HELIOS RENEWABLE
ENERGY
PROJECT

Draft Statement of Common Ground with the Environment Agency

January 2025

Planning Inspectorate Reference: EN010140

Drawing Title:
**Figure 3.4
 Solar PV Panel Elevations**

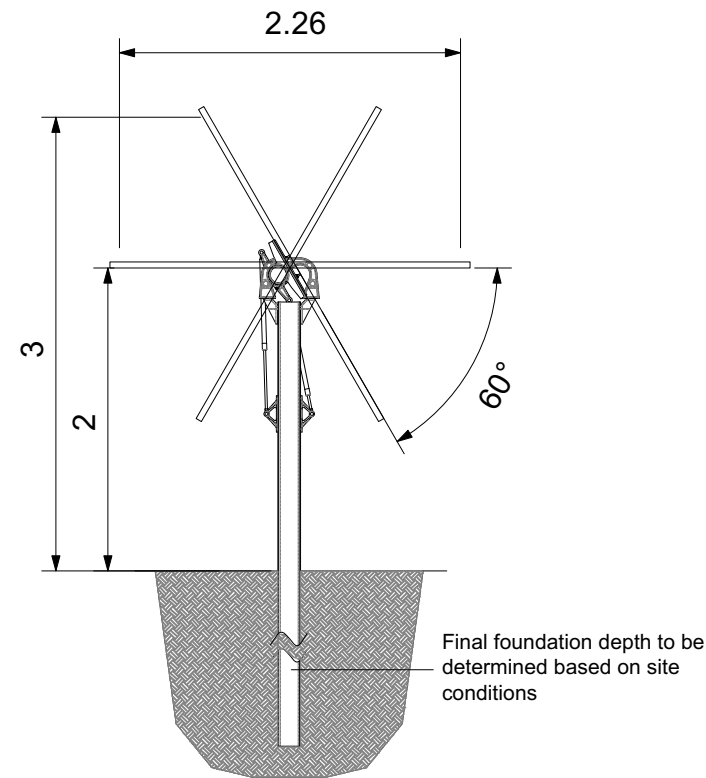
EA-08 [RR-117]	Flood Risk Assessment	<p>4. Remaining risks to the Environment which have not been addressed (continued)</p> <ul style="list-style-type: none"> <i>No calculations have been presented within the Flood Risk Assessment to confirm that the volume of flood water displaced by the solar panel supports is negligible.</i> 	<p>Paragraph 4.121 of the FRA [APP-232] states:</p> <p><i>‘The minimal cross-sectional area and spacing of the PV panel supports and equipment framework would allow the free flow of flood waters around the base of the structures. The shape of the panels’ supports would be designed to allow the free passage of water around the</i></p>	Under discussion

EA-23 [RR-117]	Flood Risk Assessment	<p>Issues relating to Flood Risk</p> <p><i>APP-232 Flood Risk Assessment</i></p> <p><i>Section 4.124 Solar Array Support Structures</i></p> <p><i>Issue - The risk of flooding has not been adequately assessed. No calculations have been presented within the Flood Risk Assessment to demonstrate that the volume of flood water displaced by the solar panel supports is negligible.</i></p> <p><i>Impact - The Flood Risk Assessment lacks the technical detail to allow displacement of flood water to be accurately assessed.</i></p>	<p>As per response to EA-08.</p> <p>We stand by our assessment that the effect of flood water displaced by the solar panel supports is negligible (Paragraphs 4.121 & 4.124 of the FRA [APP-232]). These are discrete structures across the Site. We would not typically assess the volume displaced by fence posts or landscape planting in the floodplain and the same logic applies to solar panel supports. However, to provide clarification on this point, the Applicant has now carried out the assessment work requested and has provided a copy to the Environment Agency (the ‘Water</p>	Under discussion

Ref.	Matter	Environment Agency – Current Position	Applicant’s Response	Status
			<p>support. The presence of the panel supports in flood risk areas would not materially impede water flows due to their small size, cross sectional profile and wide spacing (typically one panel support on a solar array for every 8-9m).’</p> <p>Paragraph 4.124 of the FRA [APP-232] states:</p> <p>‘Due to the nature of the proposed equipment in the area of elevated flood risk, the volume of flood water displaced by the PV panel supports and fence posts is negligible in the context of the wider floodplain and flood waters could flow freely around the panel supports, base of the structures, and security fence.’</p> <p>We stand by our assessment that the effect of flood water displaced by the solar panel supports is negligible. These are discrete structures across the Site. Due to the nature of the rotating solar arrays [ES Figure 3.4 - Solar PV Panel Elevations [APP-041] the amount of support structure is reduced compared with fixed structures. We would not typically assess the volume displaced by fence posts or landscape planting in the floodplain and the same logic applies to solar panel supports.</p> <p>However, to provide clarification on this point, the Applicant has now carried out the assessment work requested and has provided a copy to the Environment Agency (the ‘Water Environment Supplementary Assessment’ sent 09/01/25). Once the Environment Agency has reviewed this document and the Applicant and the Environment Agency have reached a point of agreement, a copy will be submitted to the Examination.</p>

Ref.	Matter	Environment Agency – Current Position	Applicant’s Response	Status
		<i>Solution - Use the area volume method to provide the volumetric displacement of the solar panel arrays in the design scenario and the potential impact on levels that this might have across the study area to demonstrate the displacement of flood water and confirm that this is negligible and would not increase flood levels.</i>	Environment Supplementary Assessment’ sent 09/01/25). Once the Environment Agency has reviewed this document and the Applicant and the Environment Agency have reached a point of agreement, a copy will be submitted to the Examination.	
EA-24 [RR-117]	Equipment levels	<p><i>Section 4.126 & 4.134 Finished floor levels</i></p> <p><i>Issue - Finished floor levels of all built development are to be set a minimum of 0.3m above ground level. This does not take into consideration the water level in a design flood event and the impacts of climate change, resulting in insufficient mitigation for the ‘credible maximum scenario’.</i></p> <p><i>Impact - The failure to raise finished floor level to the adequate level may cause the proposed development to be at risk of flooding.</i></p> <p><i>Solution - Raise all finished floor levels to a minimum of 300mm above the design flood level.</i></p>	<p>As per response to EA-07.</p> <p>It is considered the Proposed Development complies with this guidance.</p> <p>Through the sequential design of the site locating the Inverter Field Stations and Substation and BESS Compound outside of areas affected by the fluvial ‘design flood’ (where the flood depth is therefore zero) the minimum floor level of +0.3m above ground level (and up to +0.6m) would therefore be at least +0.3m above the design flood and comply with the EA’s guidance.</p> <p>Section 2 of the ‘Water Environment Supplementary Assessment provides clarification on the finished floor levels and includes a recommendation to amend the Flood Risk Assessment to explicitly state that the finished floor levels will be at least +0.3m (and up to +0.6m) above existing ground level and +0.3m above the fluvial ‘design flood’ level. Once the Environment Agency has reviewed this document and the Applicant and the Environment Agency have reached a point of agreement, a copy will be submitted to the Examination.</p>	Under discussion

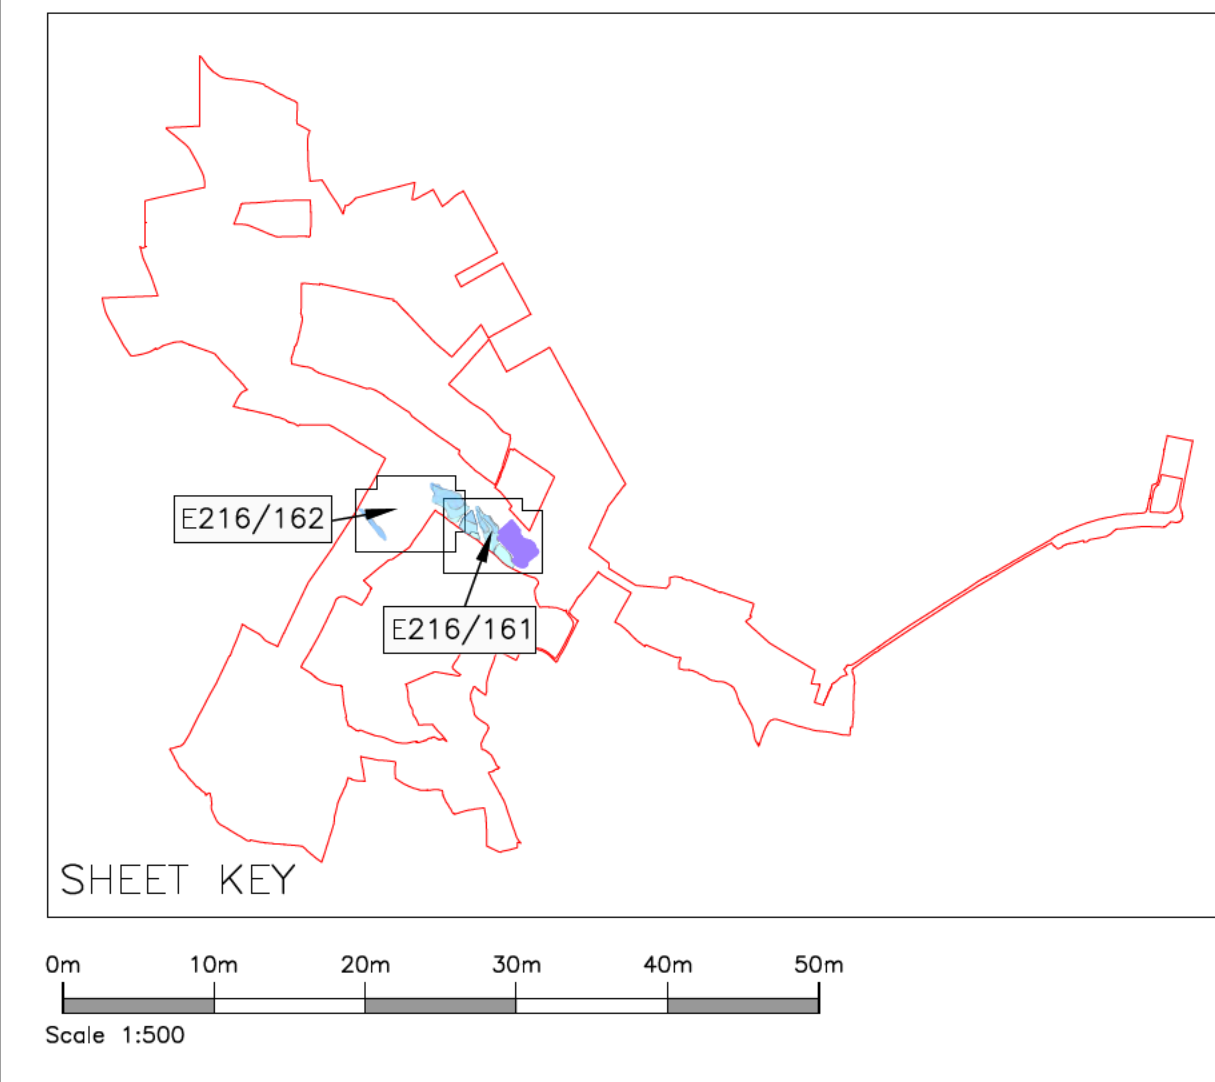
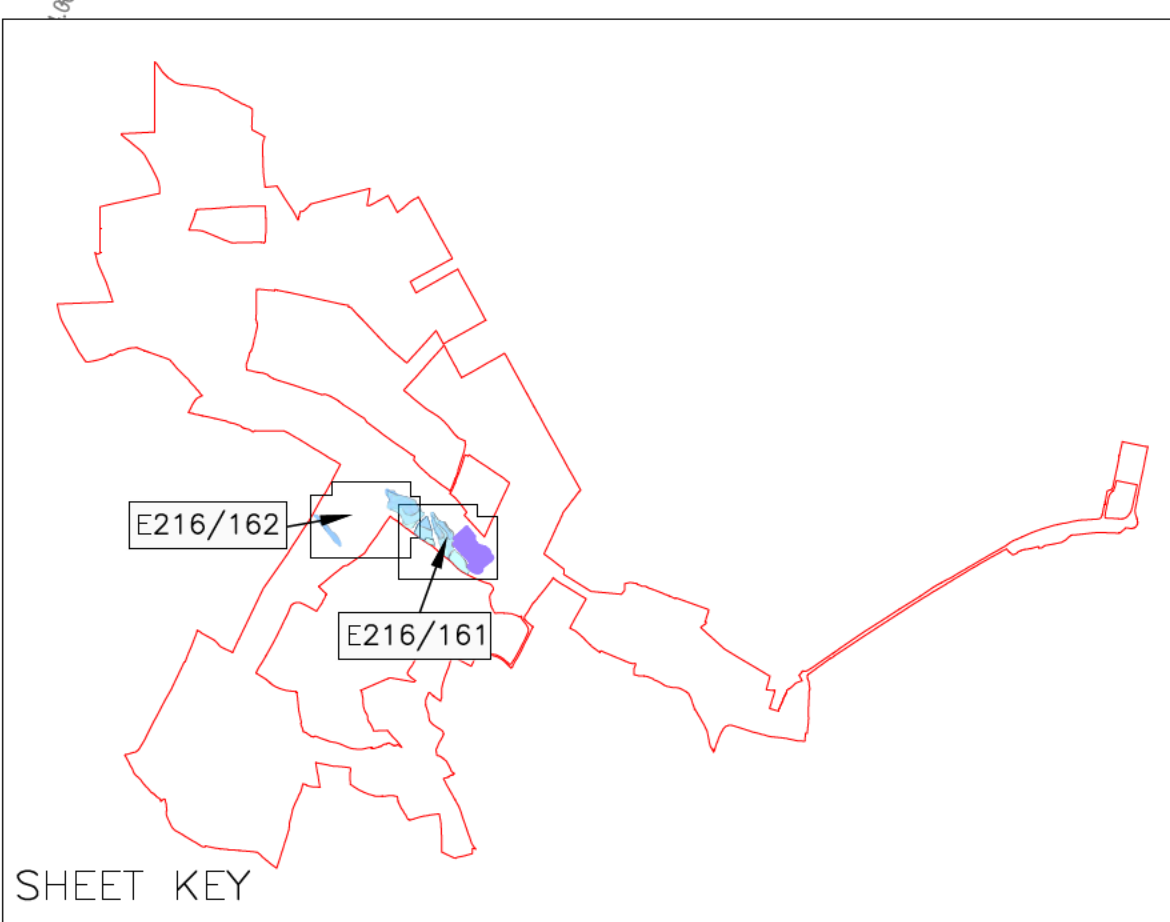
EA-26 [RR-117]	Flood Risk Assessment	<p><i>Section 4.142-4.147 Appendix 19 Floodplain compensation</i></p> <p><i>Issue - Flood compensation has not been adequately addressed. A floodplain compensation scheme is proposed (as shown in FRA Appendix 19) as mitigation for the loss of floodplain and impeding flow routes. There is no confirmation that this will be taken forward. Part 2 of the Exception Test requires the applicant to demonstrate, via a site-specific flood risk assessment (FRA), that the development will be safe without increasing flood risk elsewhere and, where possible, the development should reduce flood risk overall.</i></p> <p><i>Impact - Failure to confirm steps to reduce flood risk overall</i></p>	<p>As per response to EA-05</p> <p>Inspection of Drawing No. E216/150 contained in Appendix 11 and Drawing No. E216/153 contained in Appendix 14 of the FRA [APP-234] show that the requirement for floodplain compensation for the Substation and BESS Compound is not required in either the defended Tidal or Fluvial ‘design flood’ and would only be required in the defended Fluvial ‘credible maximum climate change scenario’ (Drawing No. E216/154 Appendix 15 of the FRA [APP-234]). The timing of the delivery of the floodplain compensation scheme is dependent on if the</p>	Under discussion

Ref.	Matter	Environment Agency – Current Position	Applicant’s Response	Status
		<i>Solution - Amend wording of FRA to commit to the proposed floodplain compensation scheme and include the scheme in Works Plans as part of the DCO.</i>	credible maximum climate change scenario comes to pass over the operational lifespan of the development. The Flood Management Strategy for the Site should be secured by a suitably worded DCO Requirement and would contain the mechanism to review the need to implement a floodplain compensation scheme for the Substation and BESS Compound against climate change scenarios over the operational lifespan of the development.	
EA-27 [RR-117]	Flood Risk Assessment	<i>Section 4.33 Site Specific Flood Model Issue - The Flood Risk Assessment refers to reporting and information which has since been superseded by a more recent hydraulic model report The Flood Risk Assessment is based on the May 2024 site specific flood model and model report. The model reporting for this is provided in Appendix 10. The final model technical note is dated 25th June 2024. These latest hydraulic model report should be included and referenced in the Flood Risk Assessment Impact - Lack of clarity regarding flood model versions. Solution - Please include the latest version of the Flood Modelling Technical Note (June 2024) as an appendix to the Flood Risk Assessment. Please ensure that this is referenced in the Flood Risk Assessment</i>	Appendix 10 of the FRA [APP-232, 233 & 234] will be updated to reference latest version of the Hydraulic Model Technical Note (June 2024) produced by Aegaea. For the avoidance of doubt, the flood modelling outputs assessed as part of the FRA have not changed. The only change is the additional sensitivity testing provided in Section 6 of the Hydraulic Model Technical Note. The sensitivity testing does not impact the conclusions of the FRA.	Under discussion
